Andrew Hartcher
Department of Planning and Infrastructure

State Significant Development: Lot 12 DP625053 Crawfords Freightlines Pty Ltd Proposed Ammonium Nitrate MHF Storage Facility

Figure 4: Individual Fatality Risk Contours

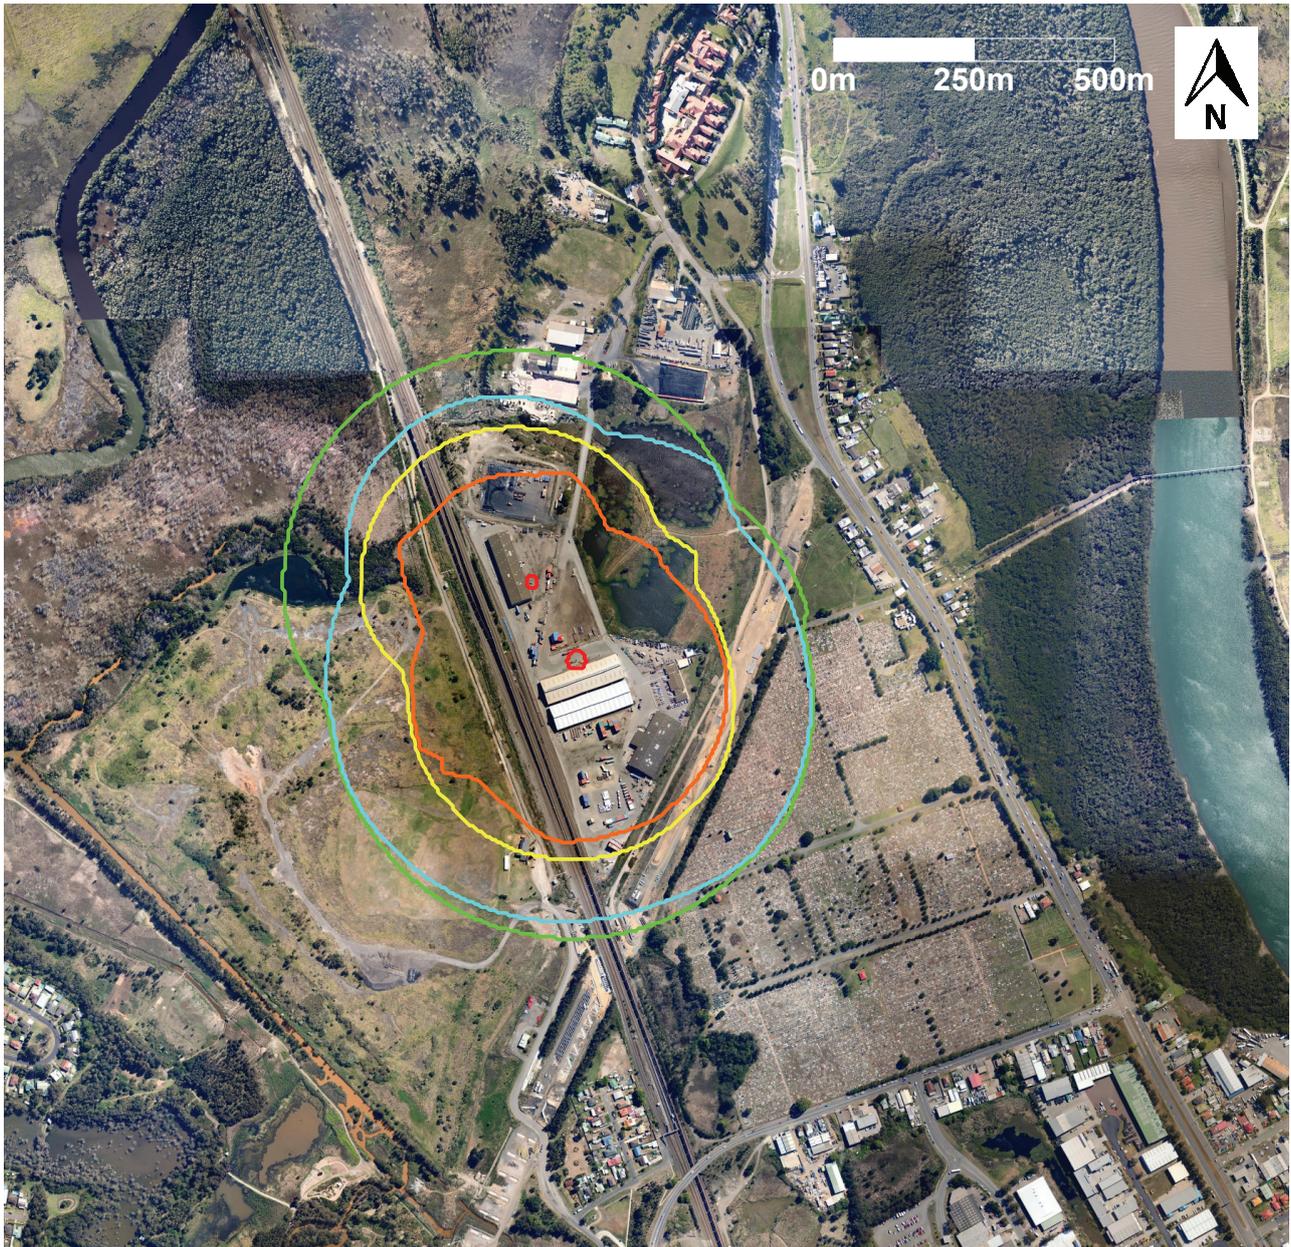
The overpressure contours provided in the EIS are underestimated.

15. With the overpressure contours being underestimated in the EIS, the subsequent Individual Fatality Risk contours are also underestimated. The distances to nearby premises and facilities provided in the HSE Study are extracted in Table 2.

16. Without going into detailed calculations, a comparison of Tables 1 and 2 indicates that the likely Individual Fatality Risk at all of these locations will exceed the HIPAP No.4 suggested criteria.
17. The storage of ammonium nitrate at the proposed Crawfords development is not "As Low As Reasonably Practicable".
18. Supporting the preceding analysis is Table 4.1 in the Western Australian *Code of Practice*. Based on increased separation distances, this code still recommends that a separation (for a 500 tonne stack) of 890m is required to "Off-site protected works" and a distance of 1,110m to "Vulnerable facilities and critical infrastructure".
19. The definition of a "protected works" is: *These are deemed to include a dwelling, public building, place of worship, theatre, cinema (or other building or structure where the public is accustomed*
